Our ref: OUT20/8717

20 July 2020

Appin Mine – Water Management Plan

Thank you for giving the Department of Planning, Industry and Environment – Water (DPIE-Water) the opportunity to review the Water Management Plan for Appin Mine. DPIE-Water has reviewed the plan and provides the following comments:

Figure 1: Appin Mine Water Accounting Framework (Water Balance)

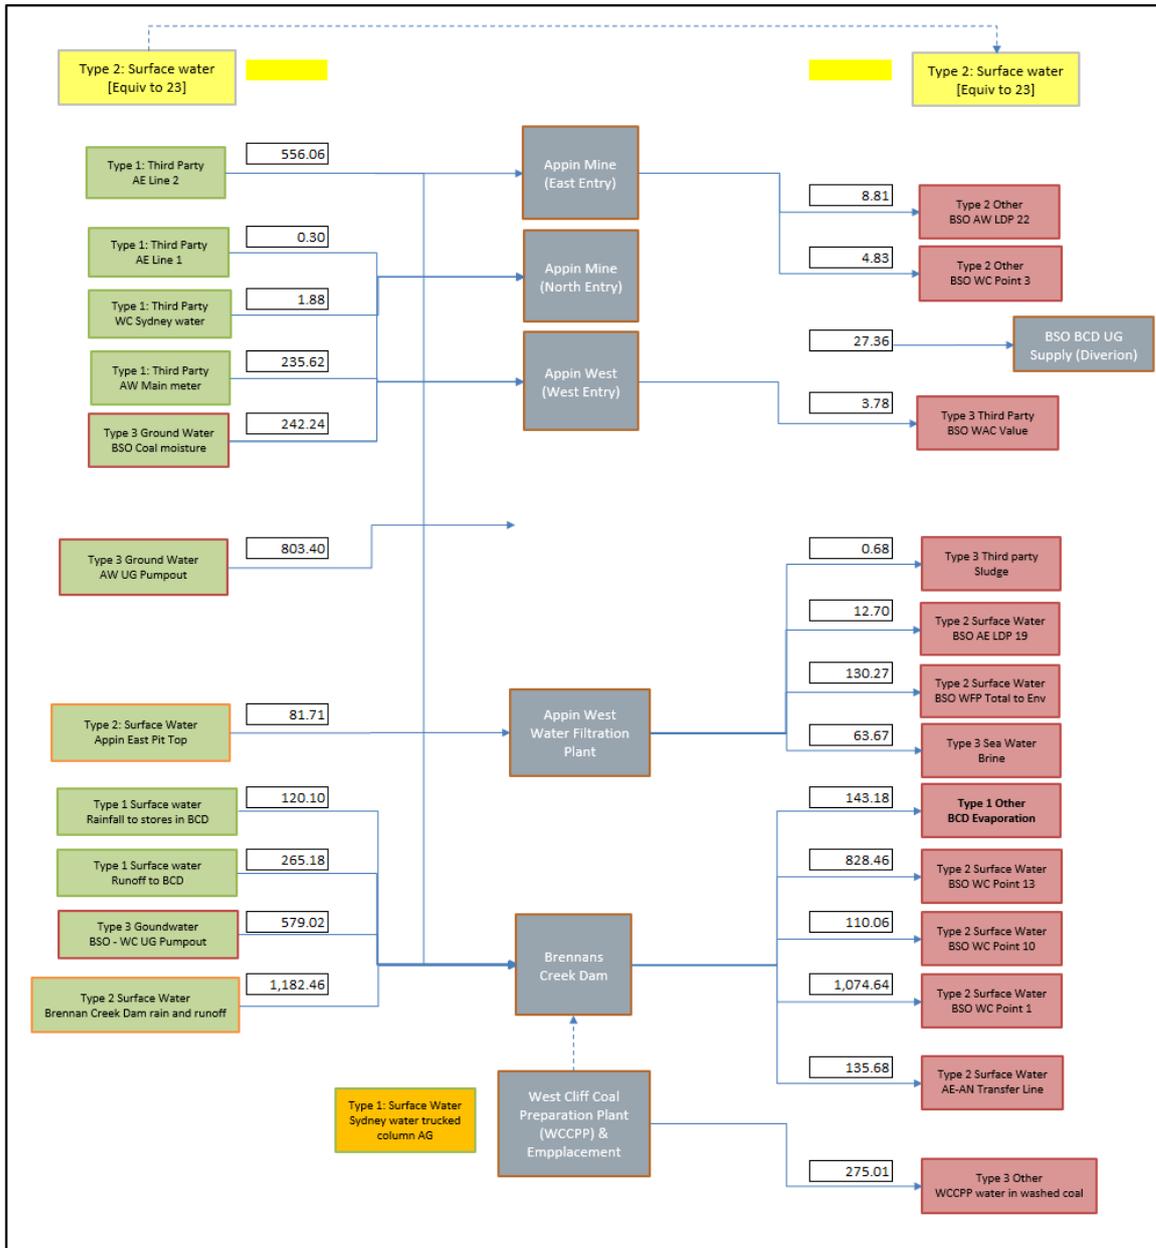
The water balance is hard to decipher, a clear tabulated water in, water used and water out with balances would greatly improve understanding.

In terms of groundwater it is interpreted from the flowchart documented that 242 ML/year is contained in product moisture; 803 ML/year is extracted from Appin West underground workings; and 579 ML/year is extracted from West Cliff underground workings. A total of 1624 ML per year of groundwater take.

DPIE-Water interpret that a water volume of 2148 ML/year is discharged from various approved discharge points. Whilst 27 ML/year is diverted to underground storage.

How much of this discharged water is groundwater or whether all the groundwater is held in the adequate underground storage is not clear.

The incidental groundwater ingress to each coal mine is not outlined. However, the overall volume is assumed to be as outlined in the water balance, a total of 1382 ML/year of pumped groundwater; this excludes 242 ML/year of groundwater as contained product moisture. This volume is stated to be directed to underground storage. The mine complex has underground storage capacity of 1710 ML/year in three storage Areas, 1, 4 and 5.
